Subject: FW: Consultation on planning application 3/2011/0595 56 Linden Lea, Chapel Hill, Longridge

I have no objection to this proposal, subject to the following conditions:

DWG No NK5

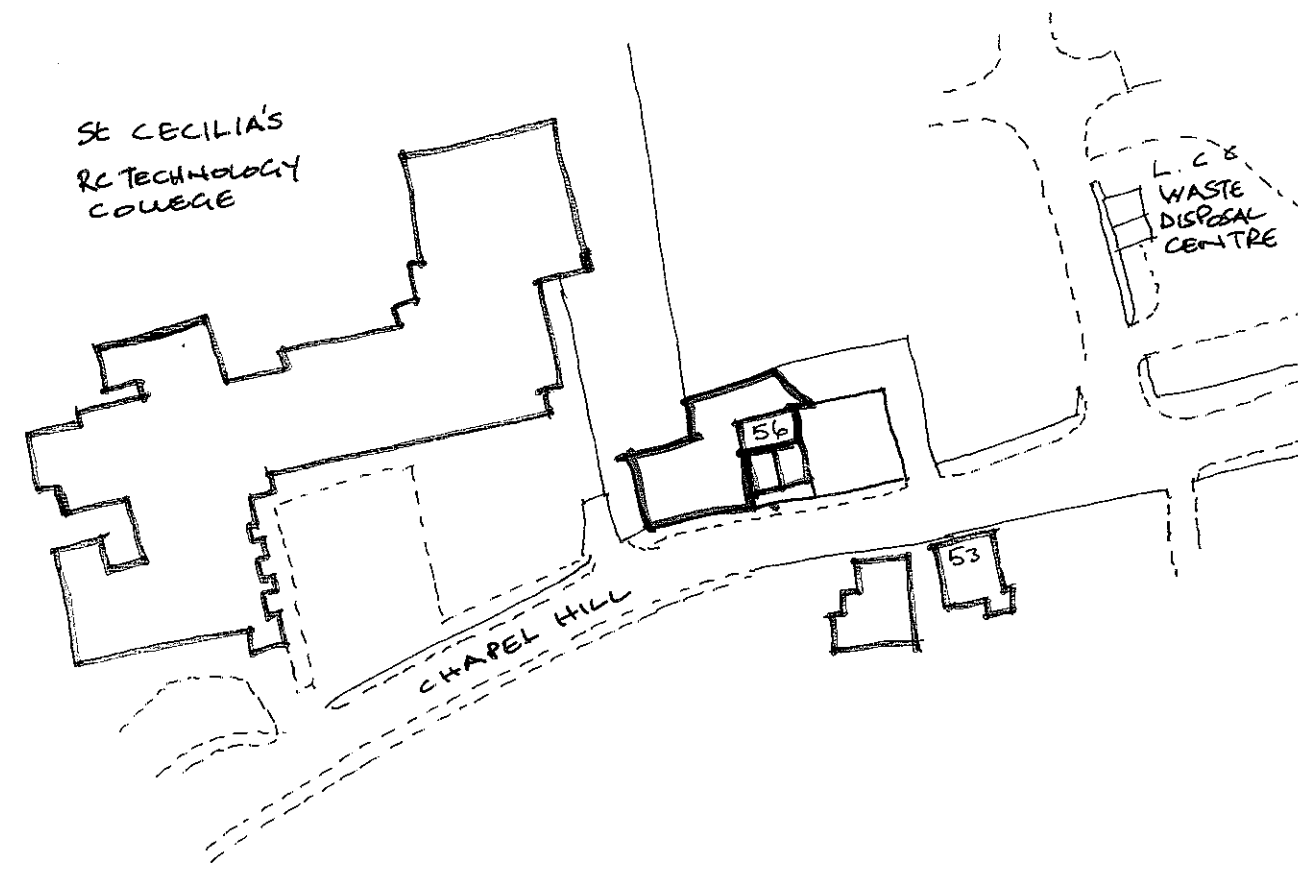
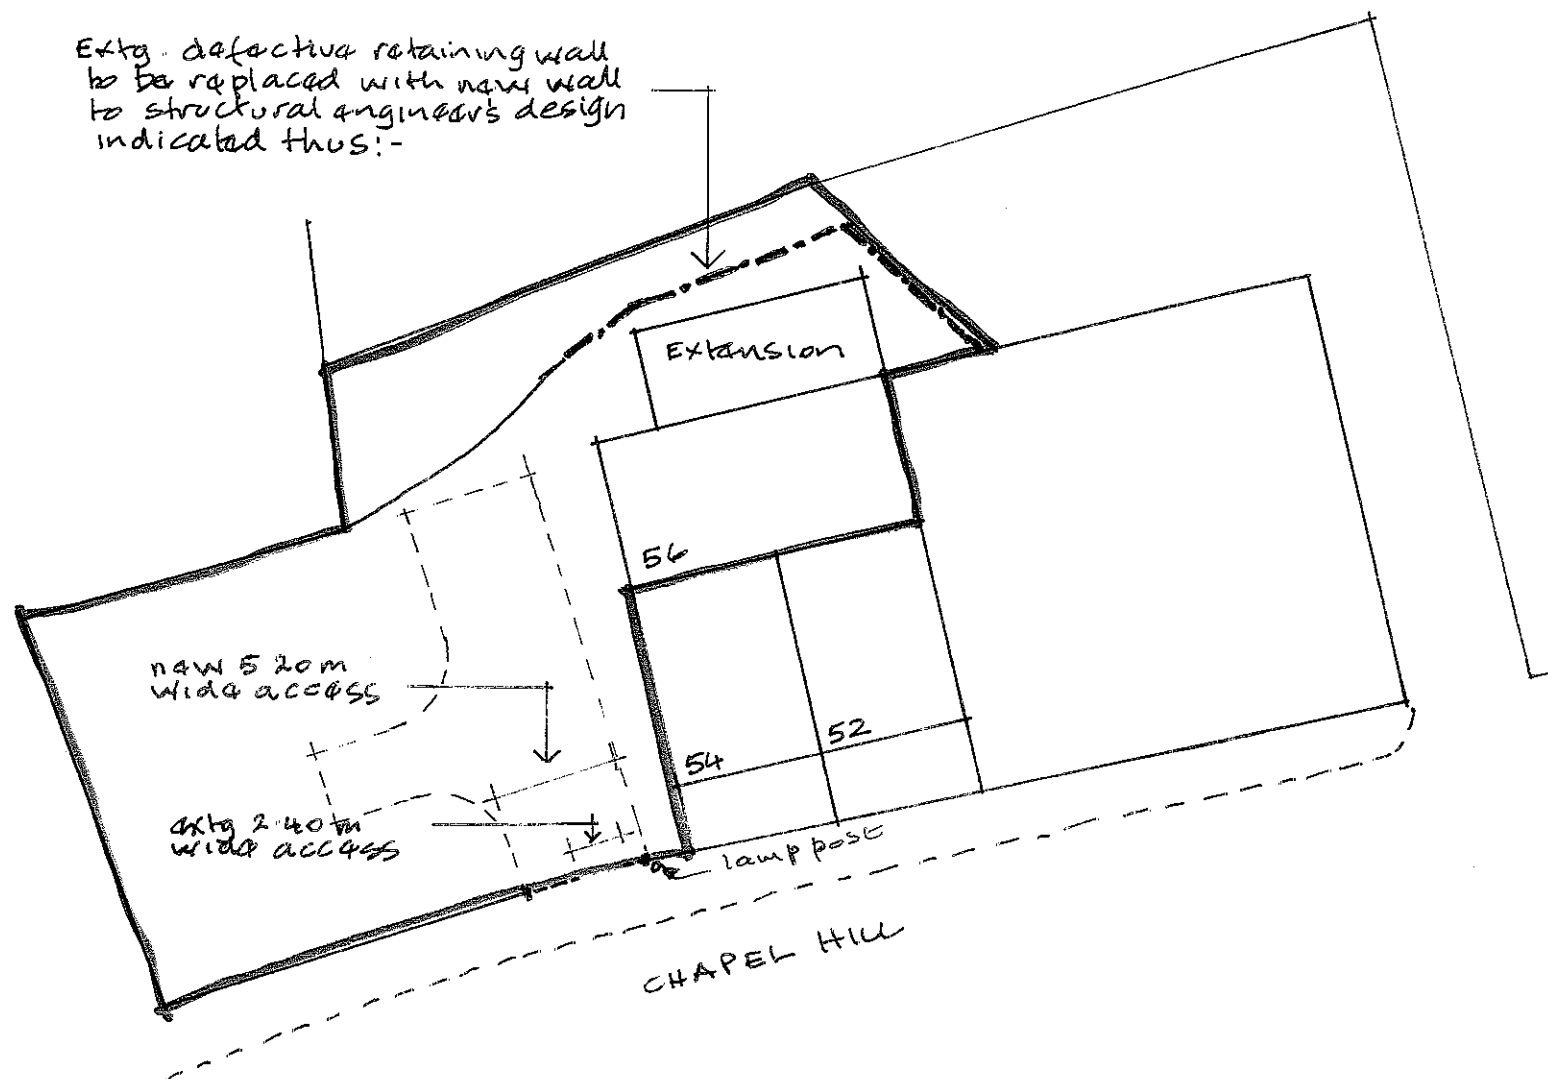
1. Any gateposts erected at the access shall be positioned 5 metres behind the nearside edge of the carriageway. The gates shall open away from the highway. Reason: To permit vehicles to pull clear of the carriageway when entering the site.

2. That part of the access extending from the highway boundary for a minimum distance of 5 metres into the site shall be appropriately paved in tarmacadam, concrete, block pavements, or other approved materials. Reason: To prevent loose surface material from being carried onto the public highway thus causing a potential source of danger to other road users.

3. The driveway shall be constructed with vehicular turning space as proposed on submitted Drawing No.NK5. Reason: Vehicles reversing to and from the highway are a hazard to other road users.

4. The existing wall on the highway frontage of the site to Chapel Hill shall be reduced to and permanently maintained henceforth at a height not greater than 1 metre above the level of the frontage footway. Reason: To ensure adequate visibility for the drivers of vehicles entering and leaving the site.

As some of the above conditions are not currently outlined in the proposed plans I am happy to discuss any of them with the applicant to ensure that satisfactory access arrangements are achieved.
